**Planning Application, Ribble Valley District
D3-12-0247 land near Sycamore Gardens, Gisburn**

I am recommending refusal of this application on highway safety grounds.

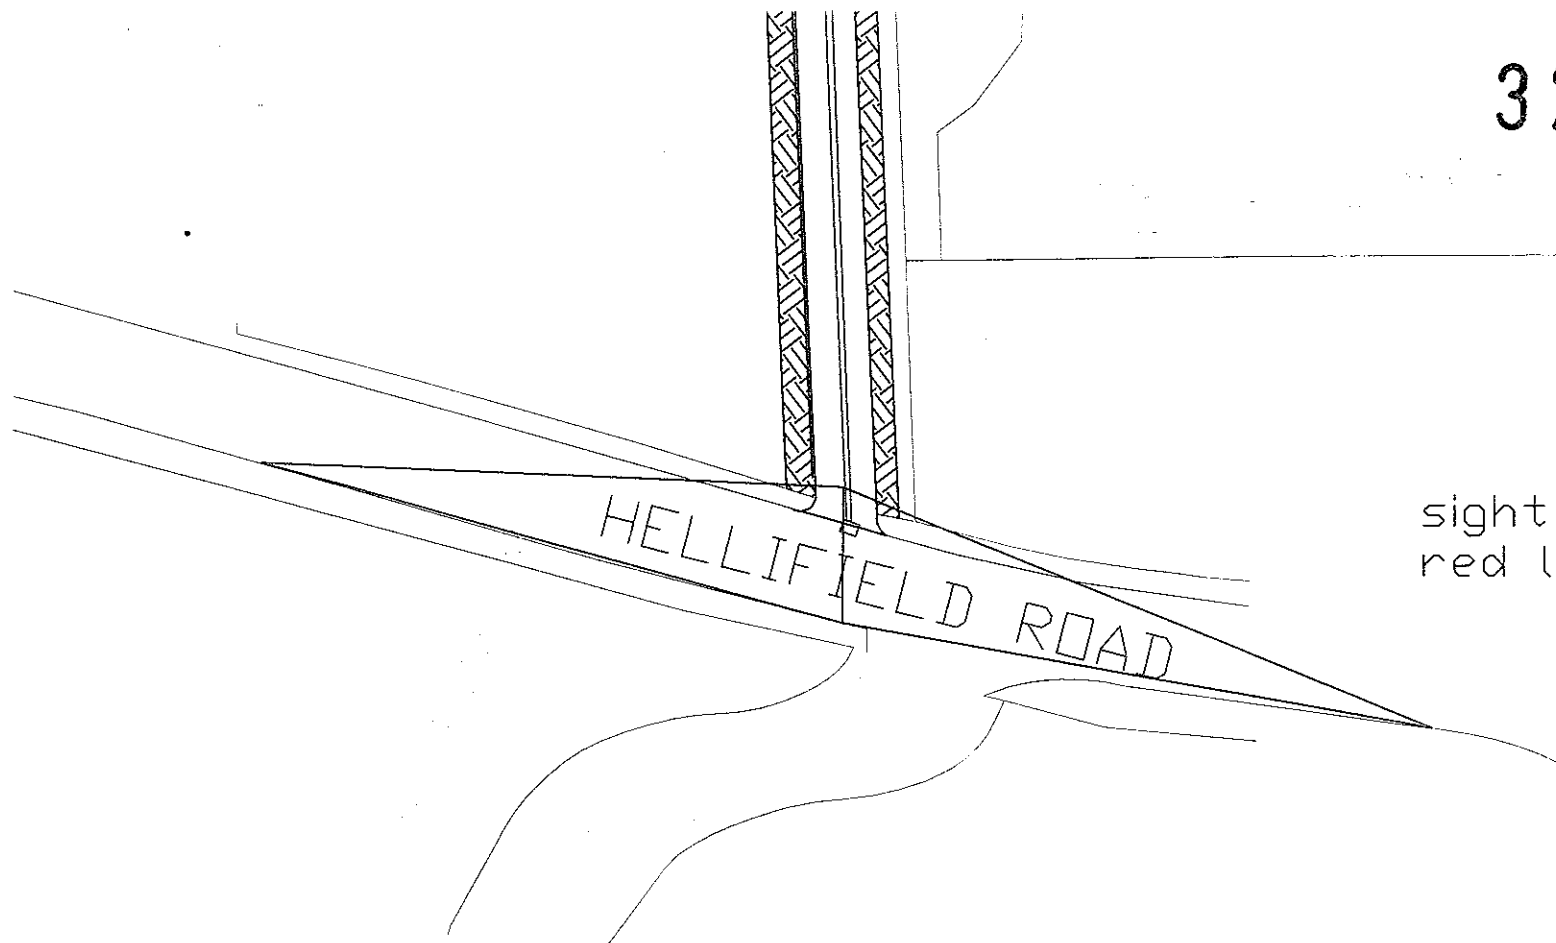
The design of the proposed new vehicular access onto the A682 Hellifield Road from the north of Sycamore Bungalows does not provide a safe means of access. I have concerns regarding the ability of the proposed access to secure the safe movement of vehicles to and from the highway due to its width and the limitations of the visibility splays that can realistically be achieved.

1. The access width must be a minimum of 5.25m for a distance of 10m back from the edge of carriageway. This is to ensure that vehicles can turn off the main carriageway onto the access road without impediment from emerging traffic.

2. The sightlines are to be taken from 2.4m back from the edge of carriageway and must extend for 50m to the south, to include movements at the A59 mini-roundabout and for 70m to the north.

3. The height of the adjacent boundary wall to the south must be reduced and all planting and construction within the visibility splays referred to above, must be maintained at a height below 1.0m.

5. The parking layout should incorporate a basic turning head to allow convenient access and manoeuvring from the available spaces.
